Your reference :
Our reference : EF13/3764; DOC15/125892
Contact : Ms Sheridan Ledger; (02) 6332 7608

17 April 2015

ULAN COAL MINE – CONTINUED OPERATIONS PROJECT (08_0184 MOD 3)
EPA COMMENT

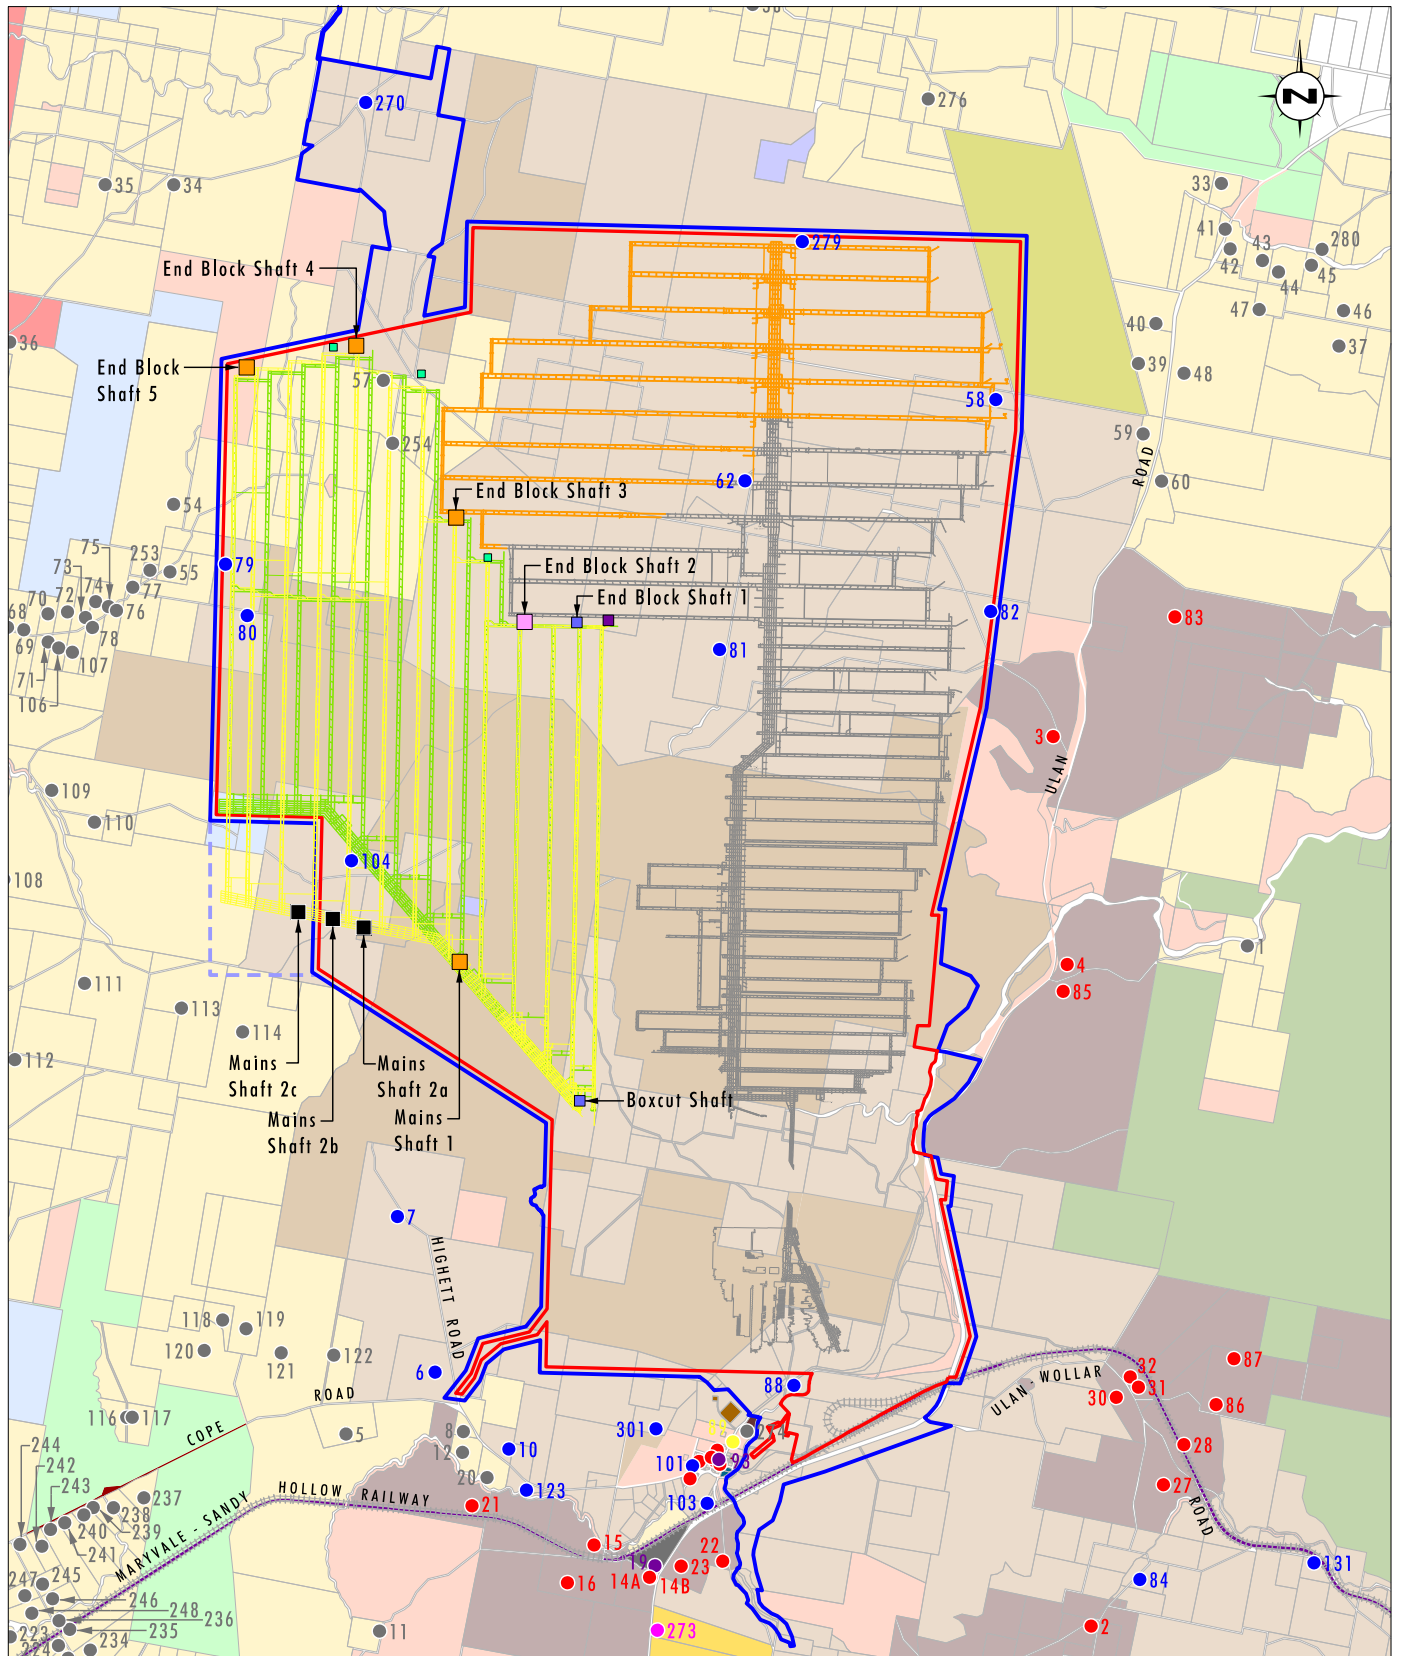
The EPA notes the predicted noise levels at receivers R57 and R254 during the proposed construction of end block shafts 4 and 5, in particular that the predicted noise levels will not exceed the original Project Specific Noise Levels (PSNL) by 5 dB(A).

The EPA recommends:

- the Noise Management Plan for the Mine be updated to include a monitoring program specifically for receivers R57 and R254 during the construction period;
- the Mine specifically defines "adverse" weather and that a Trigger Action Response Management Plan (TARP) be developed and implemented utilising this definition in conjunction with the noise monitoring program for receivers R57 and R254 to respond to any elevated noise levels; and
- that any approval granted by DPE for the Proposal includes conditions requiring the implementation of the noise management strategies contained in the EA which aim to reduce noise levels at receivers R57 and R254.
